KITTITAS COUNTY

DEPARTMENT OF PUBLIC WORKS

DATE: January 16, 2018

RE: Hyak PUD Final Development Plan REVISED COMMENTS

DEVELOPMENT, STORMWATER AND PARKING PLAN - PARCEL A

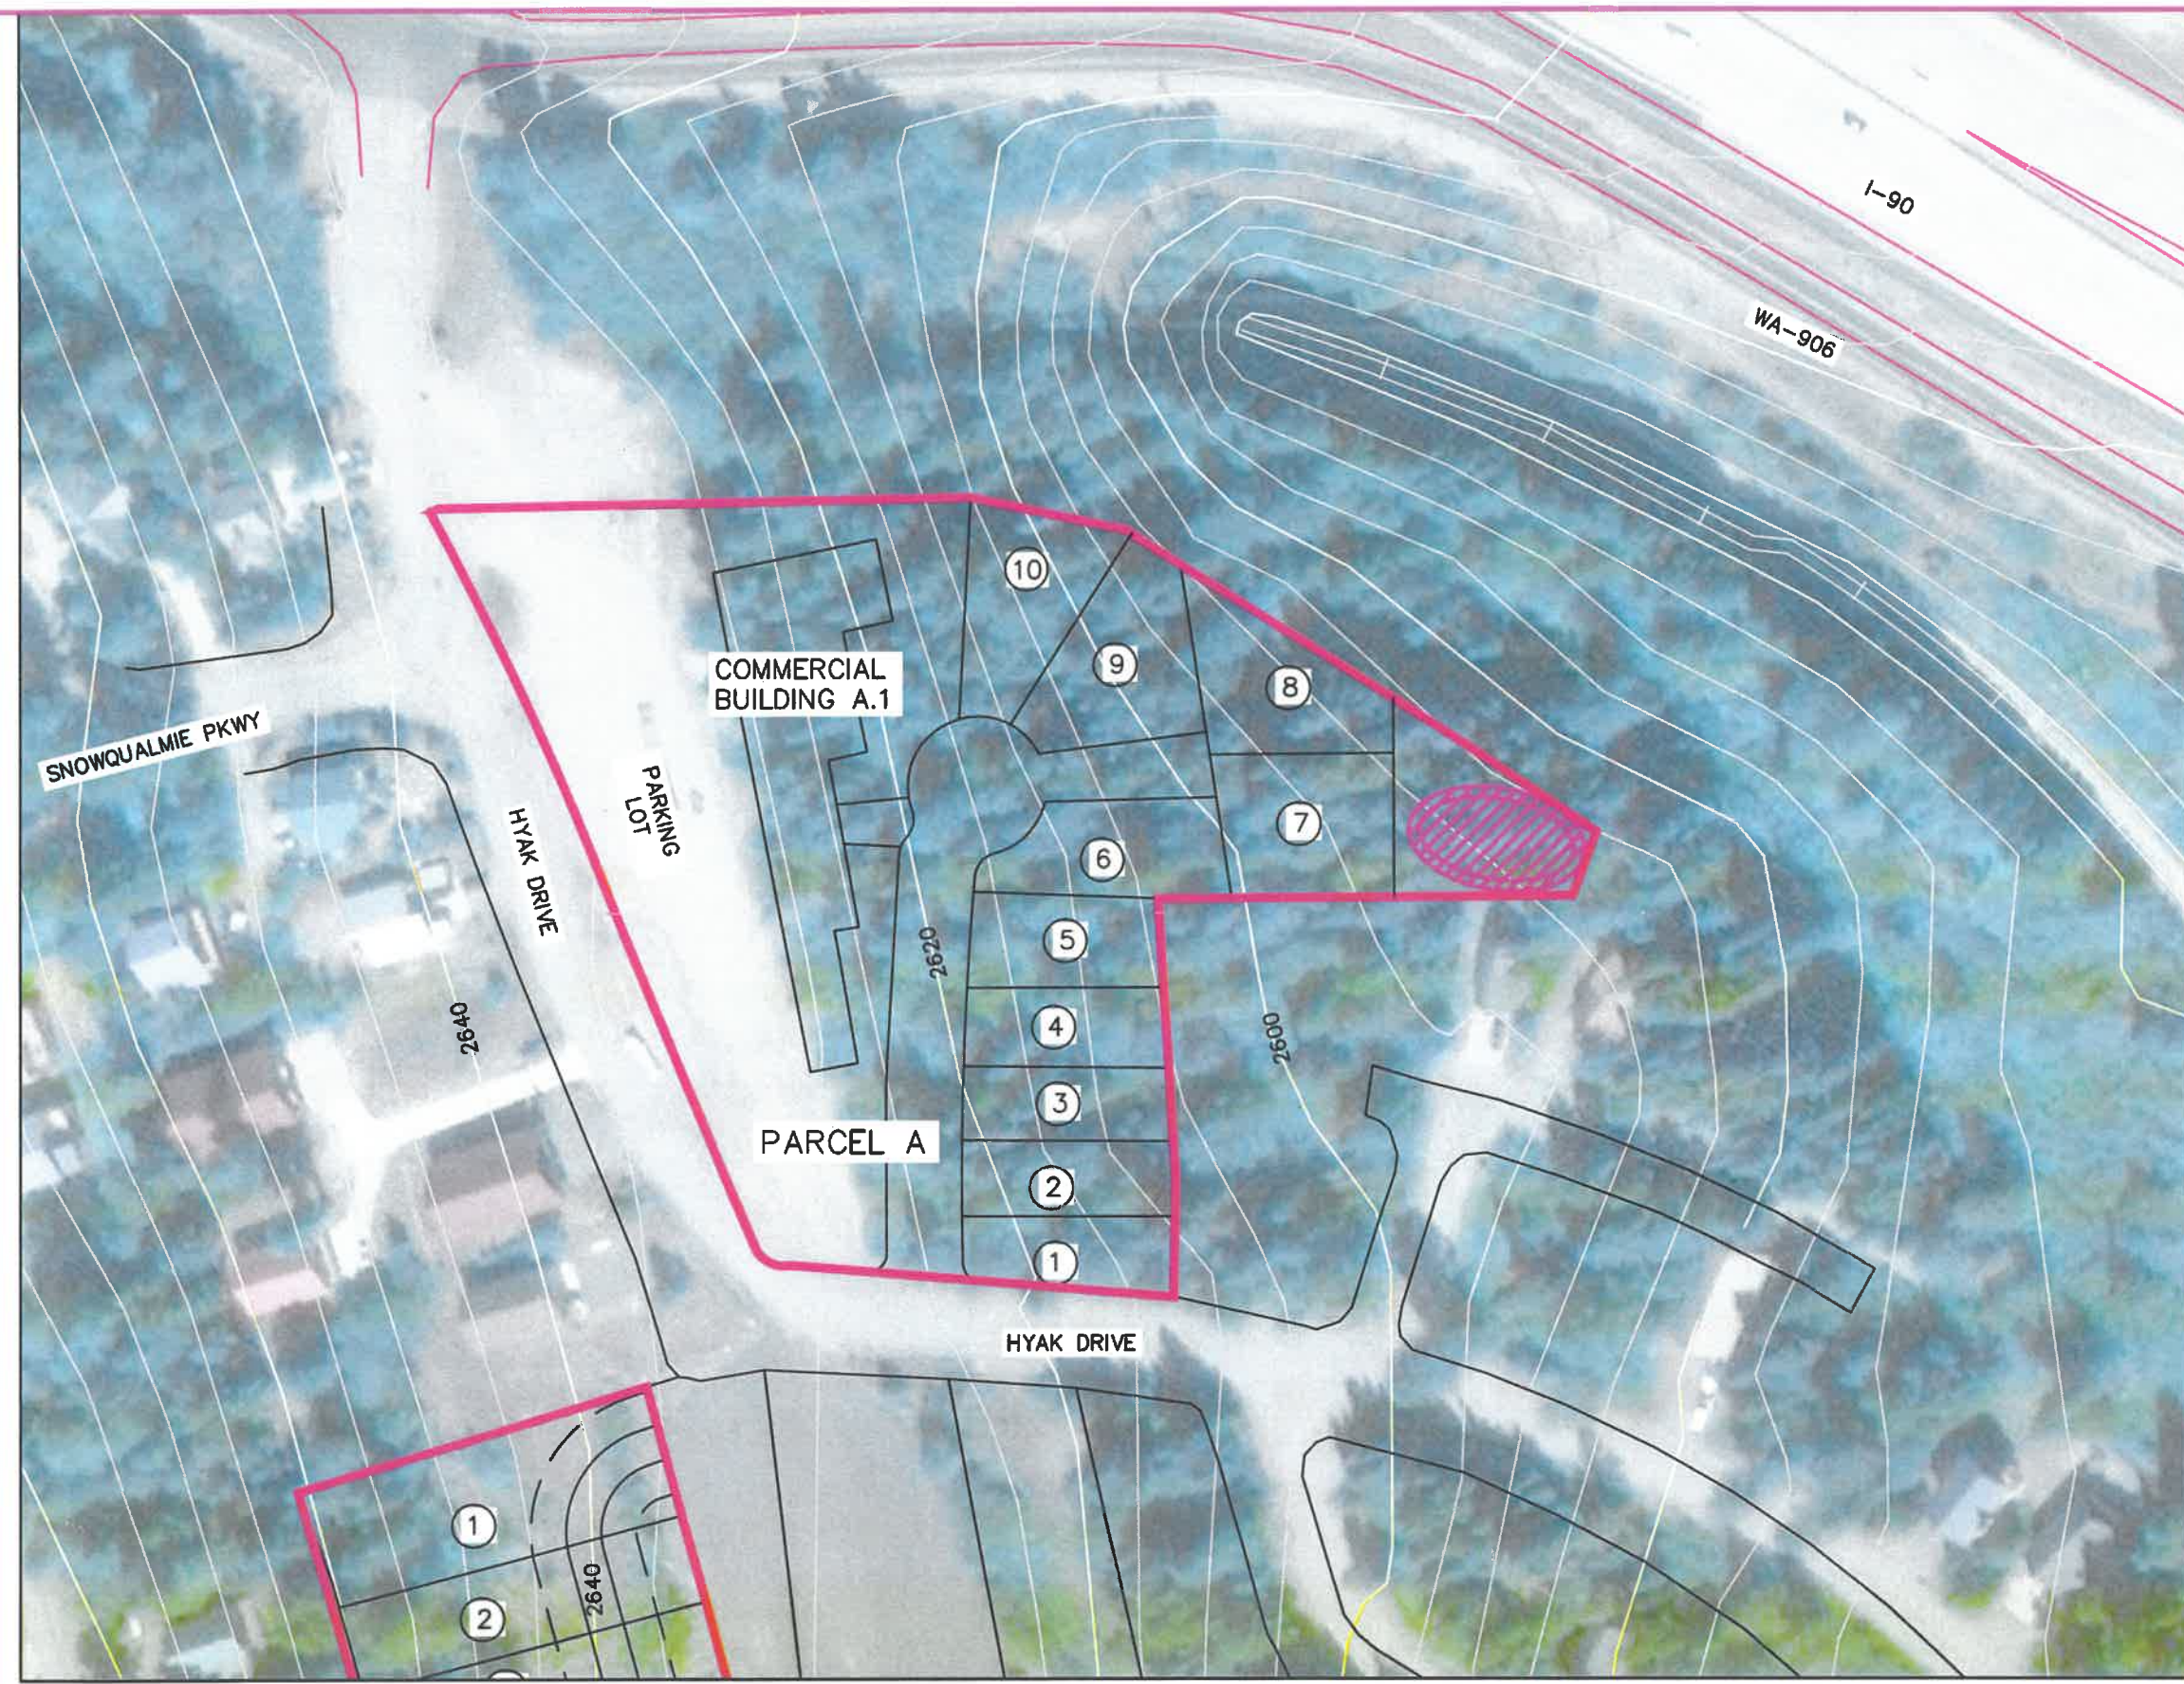
3. The proposed 25 underground parking stalls supporting the commercial use element in Parcel A (20,000 SF) is inconsistent with ITE data on commercial uses generating travel demand. A commercial apparel store is estimated to develop and average of 4 trips per peak hour per 1,000 SF. This suggests a potential of 80 peak hour trips with only 25 parking stalls. The developer is encouraged to refine the commercial land use proposal and provide sufficient parking supporting the actual commercial use. Specific parking demand will be evaluated during final plat submittal.

Activity Center Parking Table

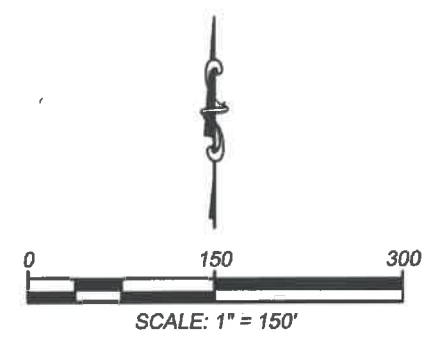
4. The 6,000 SF proposed activity center in Parcel E proposes 20 parking stalls. ITE suggests as many as 90 weekday trips based on land use code 435. 12 peak hour trips are also identified. The activity center has the benefit of being able to refuse patrons; the

developer is encouraged to revisit the number of proposed parking stalls. The specific parking demand will be evaluated during final plat submittal.

HYAK SNOW STORAGE EXHIBIT

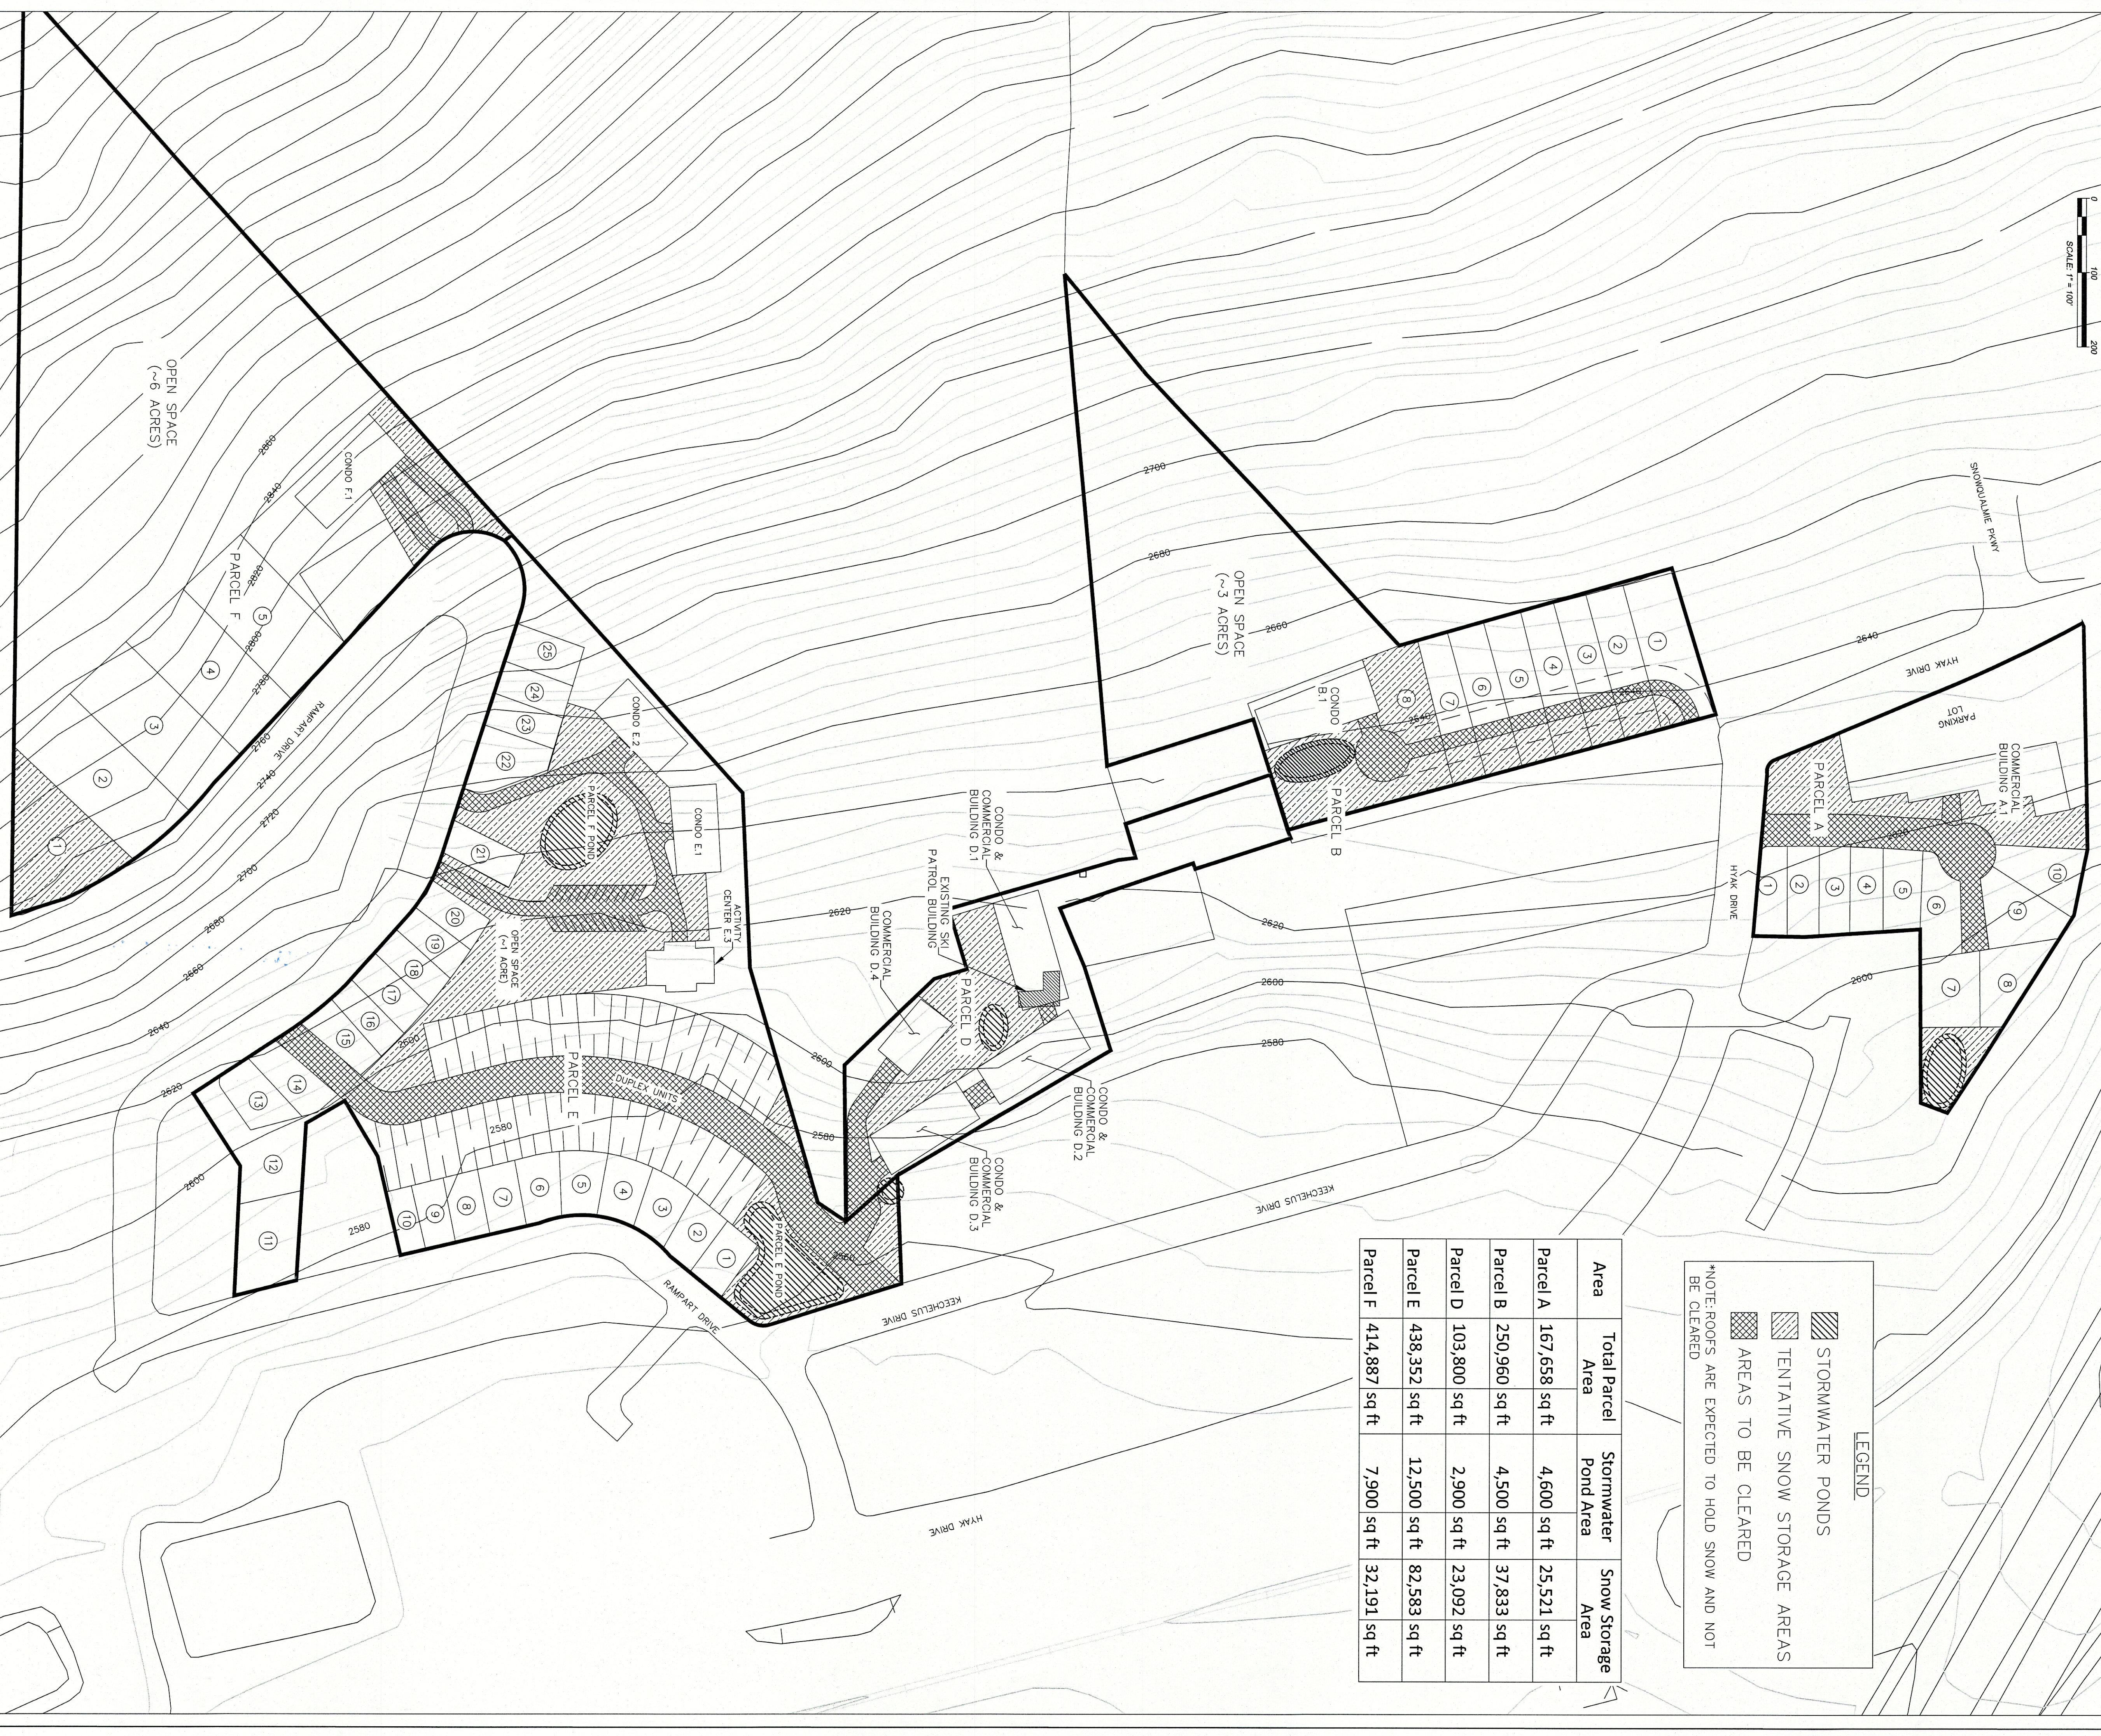
1. Public Works is experiencing increasing inability to remove snow within the Hyak Community. The issue is development of vacant parcels eliminating the ability to target our snow blowers. The proposed development will exacerbate this condition. It is likely that at some point in the near future, property owners in Hyak will be required to participate in mandatory Road Improvement District (RID) addressing increasing maintenance costs associated with snow removal. The exact specifics of snow removal and storage will be addressed during final plat submittal.

6. Proposing snow storage in stormwater ponds is problematic given that the facilities will likely be much smaller in final design than the conceptual plan as provided. Presuming snow storage in stormwater ponds is possible, spring runoff will likely result in area flooding as the ponds will not be available for snow runoff water. The lack of contour data does not assist in evaluating the feasibility of the proposal.
